Please see the below comment as an addition to the document titled "Five Estuaries NFFO Written representation" submitted by the NFFO on 21/10/2024.

This written representation forms the response from the NFFO to key documentation of concern to the fishing industry that forms part of the examination of the Five Estuaries offshore wind development.

Fisheries Liaison and Coexistence plan

Figure 3.1: Organogram highlighting key fisheries liaison roles and responsibilities.

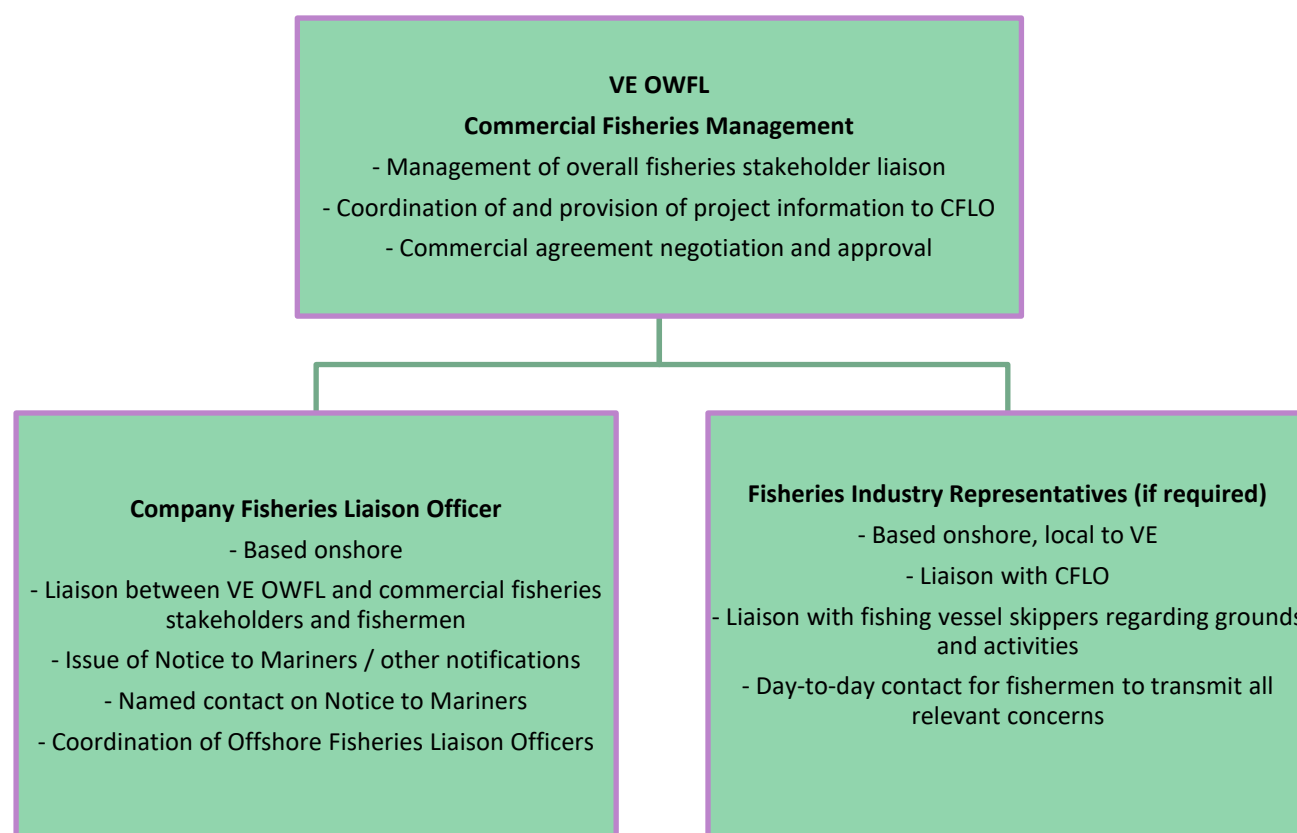
Figure 3.1 Suggest adding OFLO here.
